Subject: VA-20-00001 Brown - Notice of Application

CDS is requesting comment on the following Setback Variance application VA-20-00001 Brown.

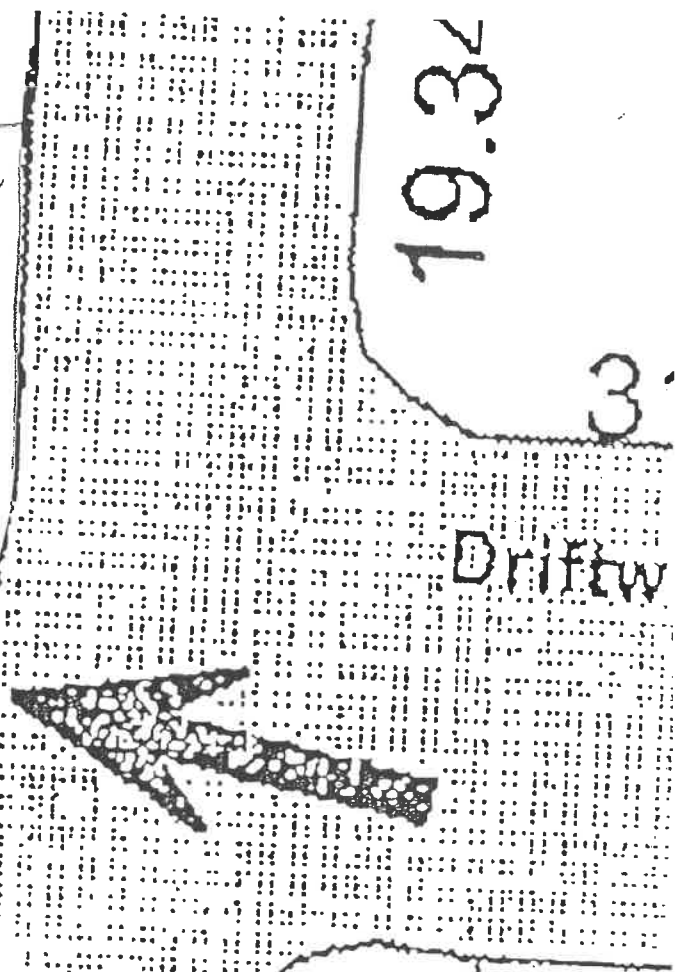
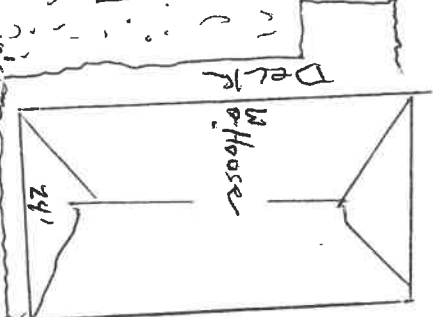
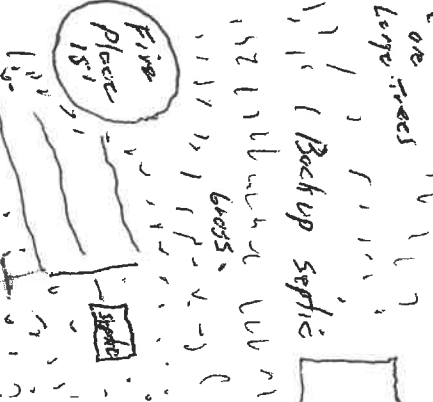
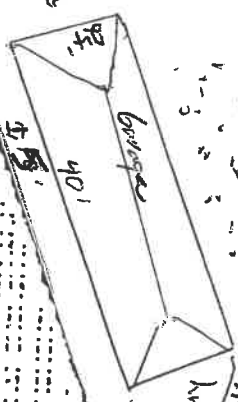
The proposed new structure foundation can be no closer to the drainfield laterals than 10 feet.
